Environmental Health Division  
1675 W. Garden of the Gods Road  
Suite 2044  
Colorado Springs, CO 80907  
(719) 578-3199 *phone*  
(719) 578-3188 *fax*  
[www.elpasocountyhealth.org](http://www.elpasocountyhealth.org)

### **Judge Orr RV Park and Storage, PPR-16-040**

Please accept the following comments from El Paso County Public Health regarding the project referenced above:

**PUMPING CHAMBER**  
N.T.S.

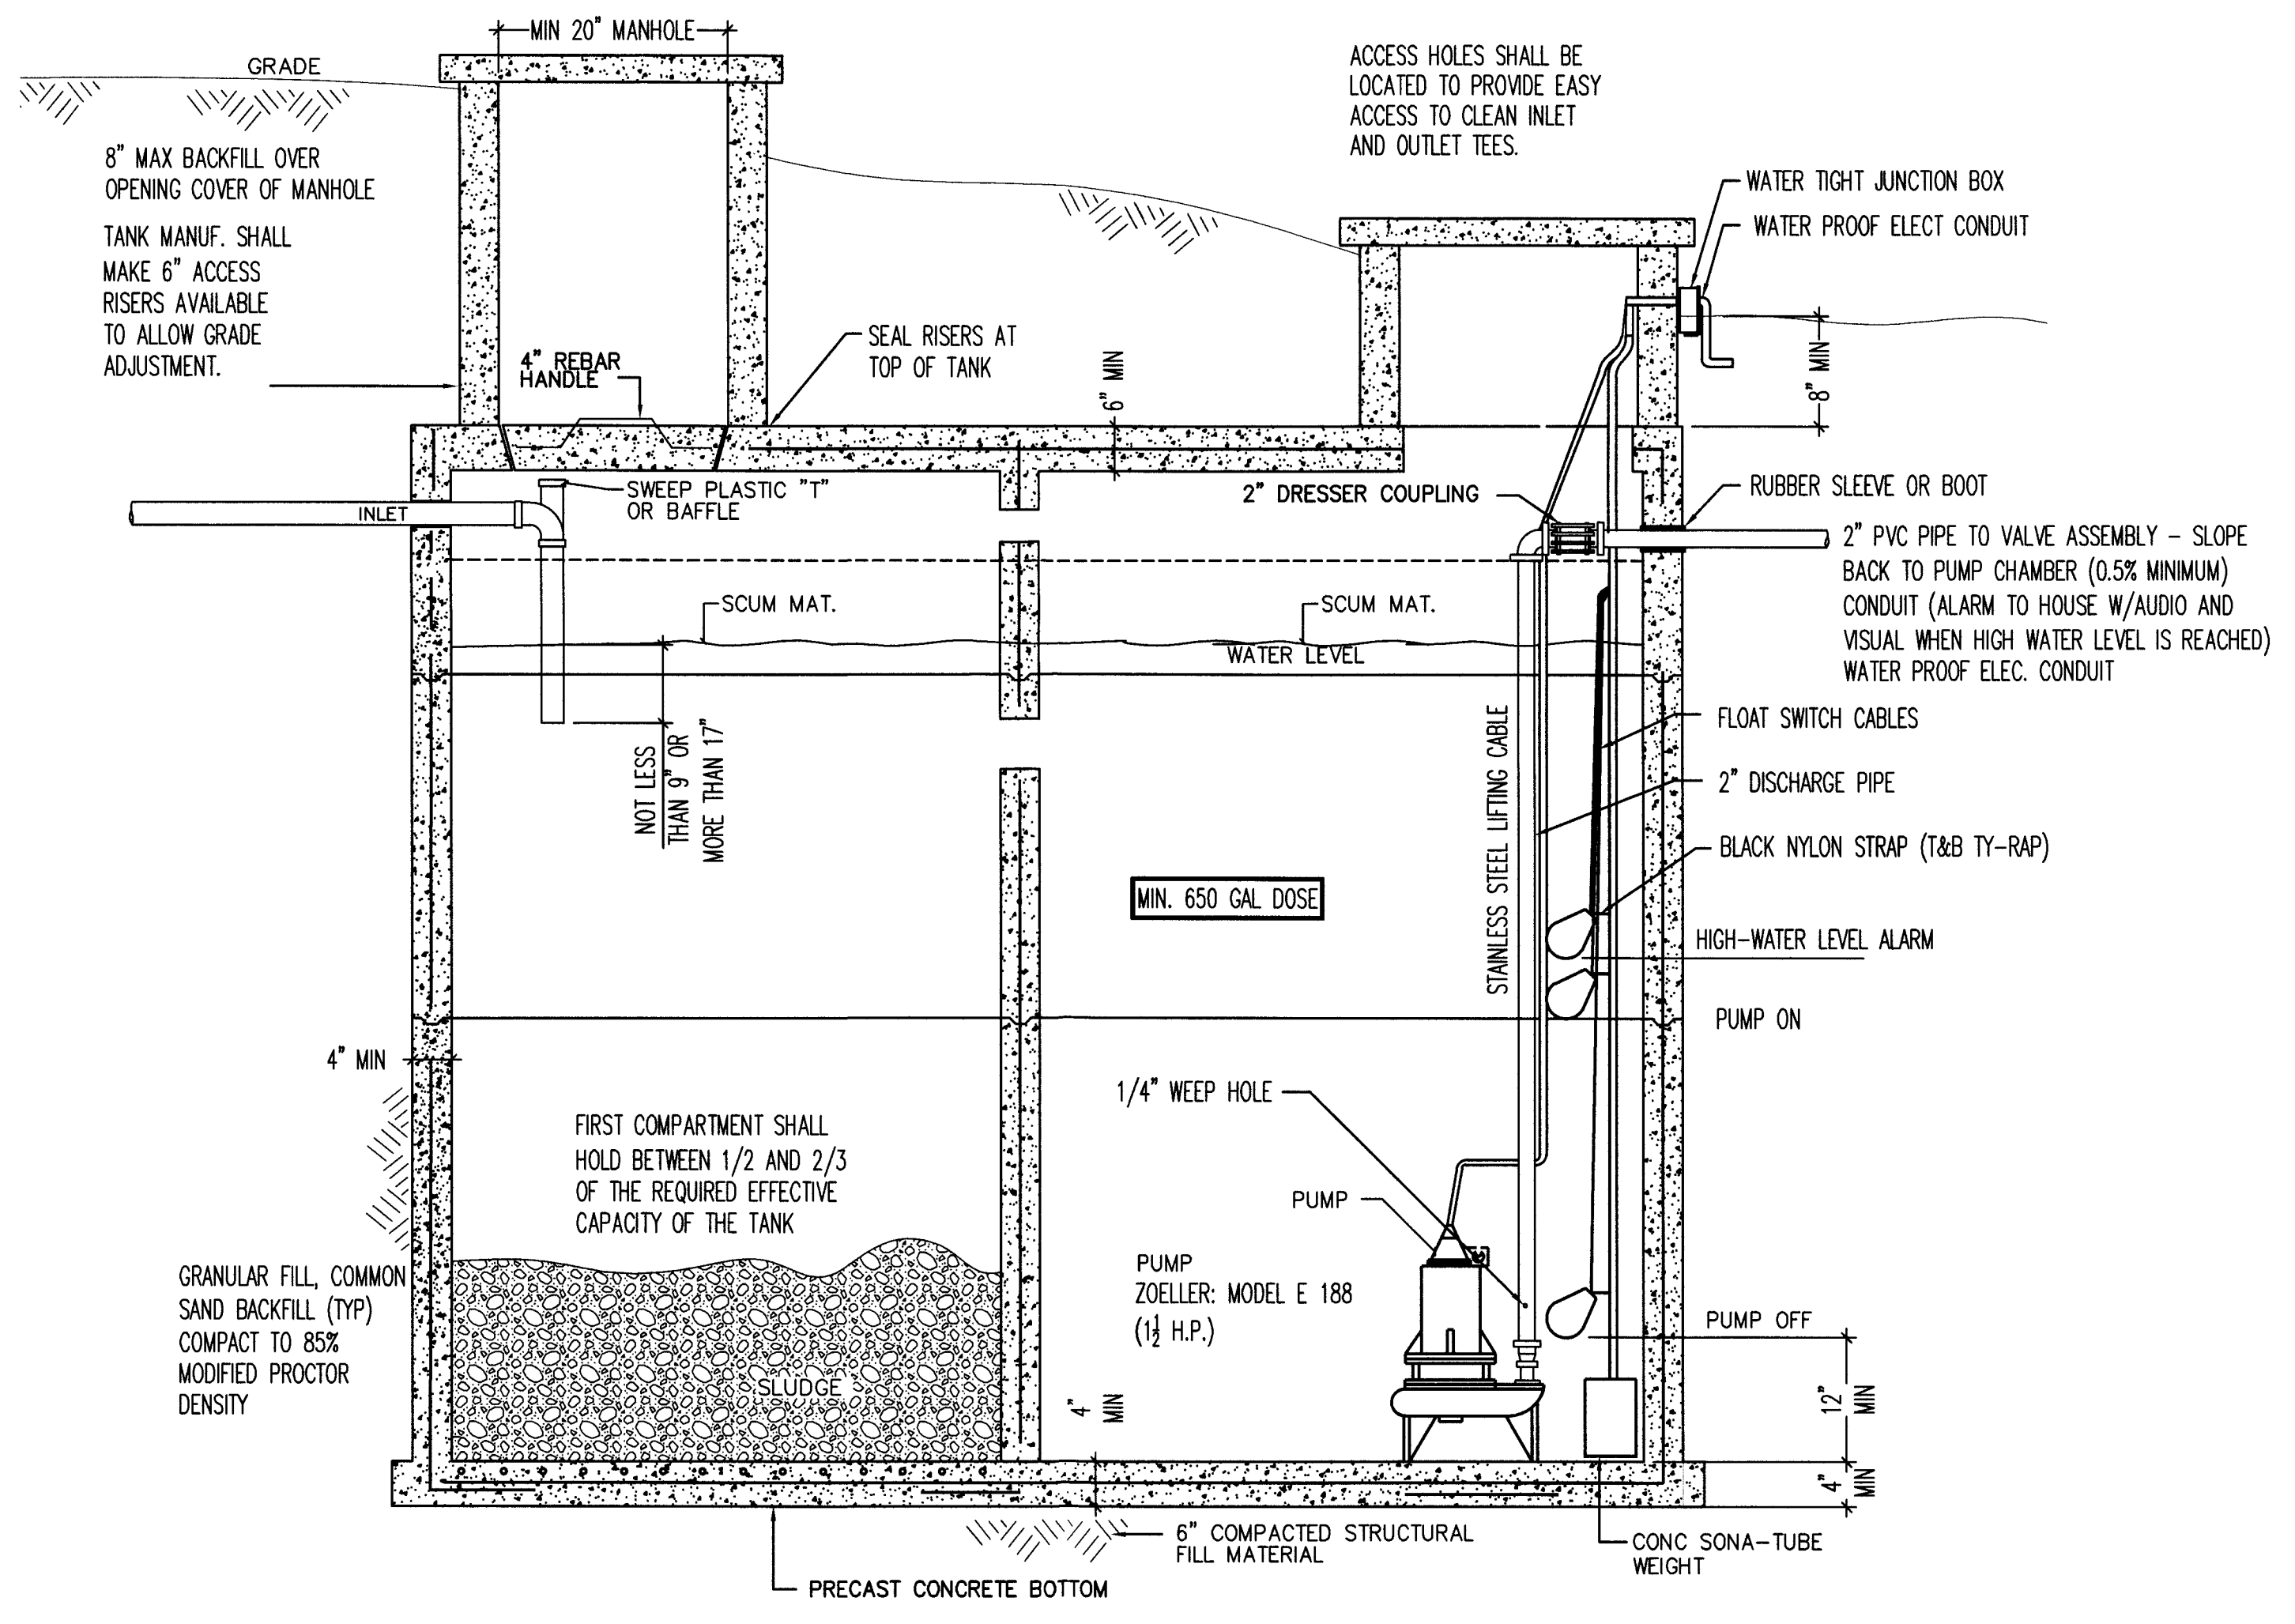
- The onsite wastewater treatment system (OWTS) must be designed to meet the all the requirements of Water Quality Policy No. 6, or it will be required to be submitted for Site Application, under Regulation 22, due to the wastewater flow design exceeding 2,000 gallons/day.

FIG NO.:

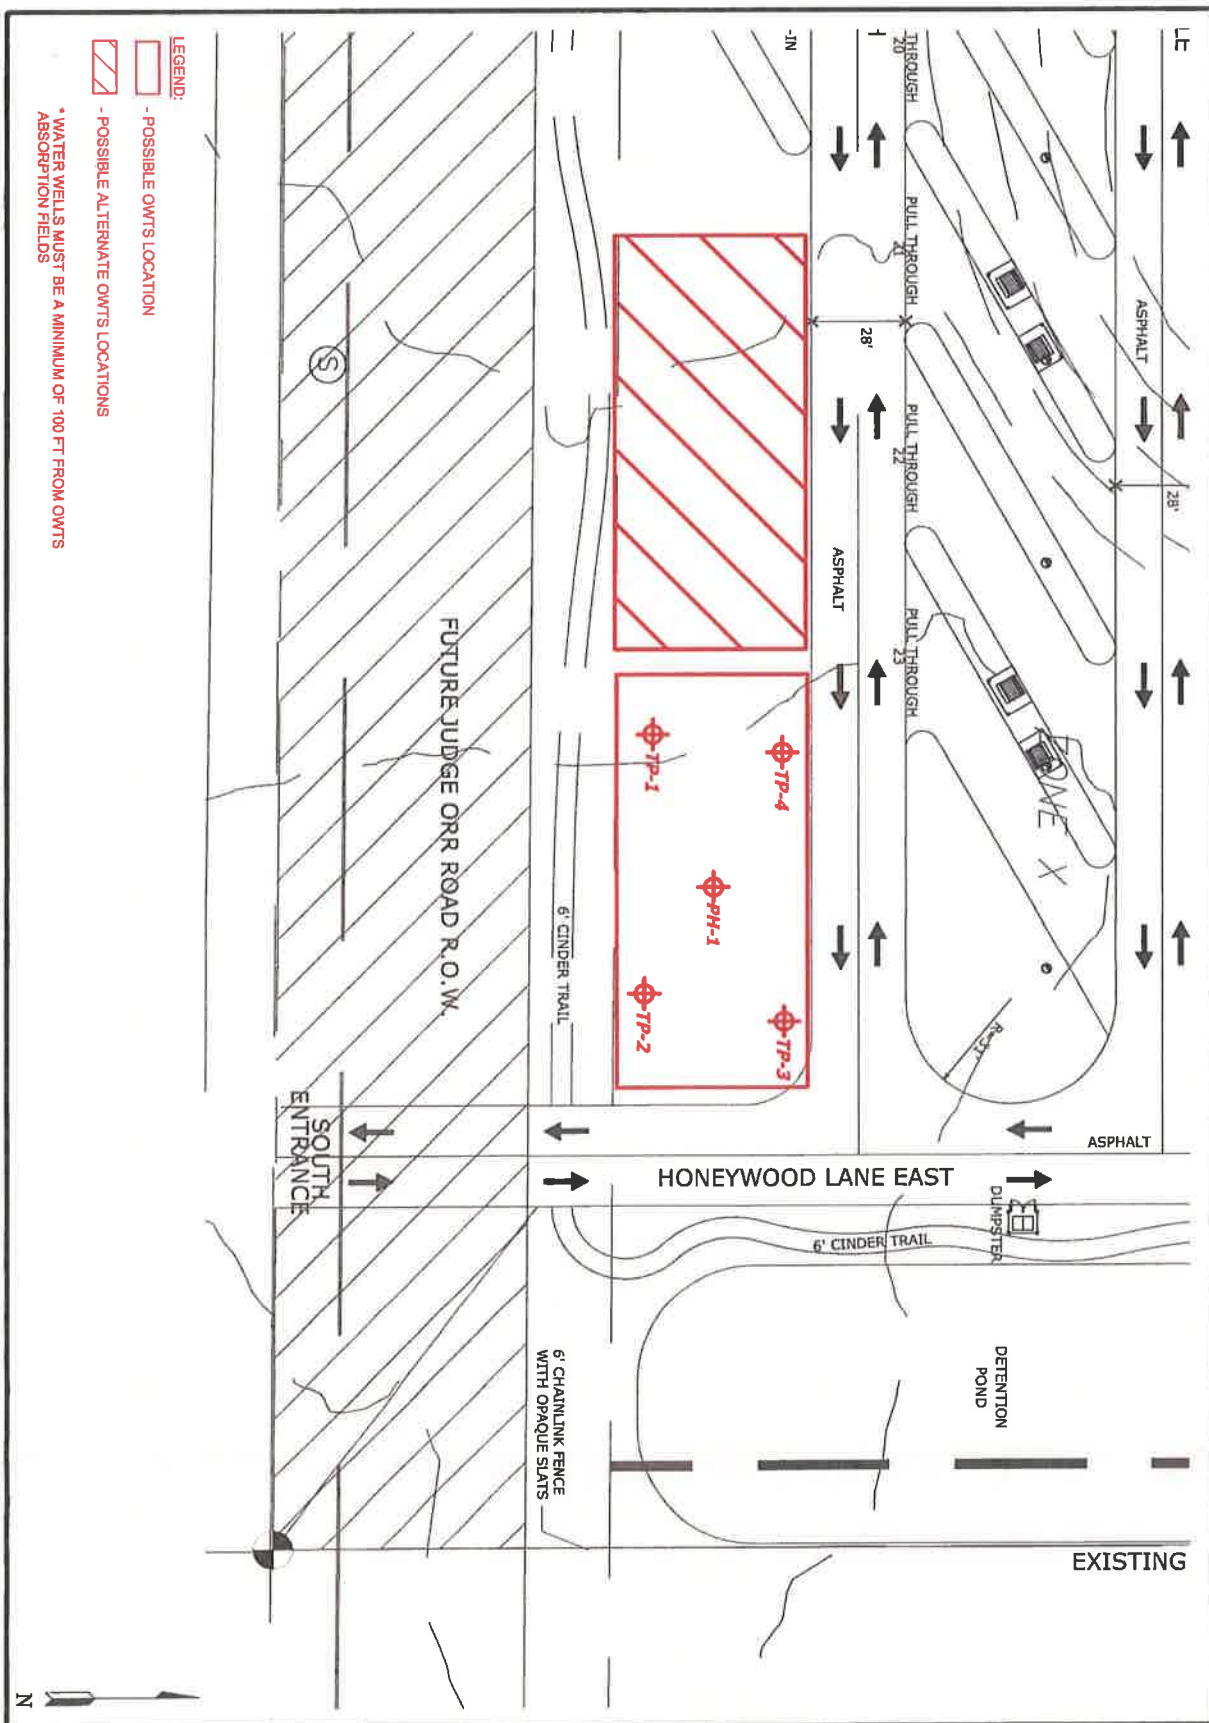
- The two proposed soil treatment areas (STA's) are required to be protected from compaction during construction. Construction fencing is encouraged, although other barriers that prevent vehicles, roads and construction activity from compacting the areas are acceptable.
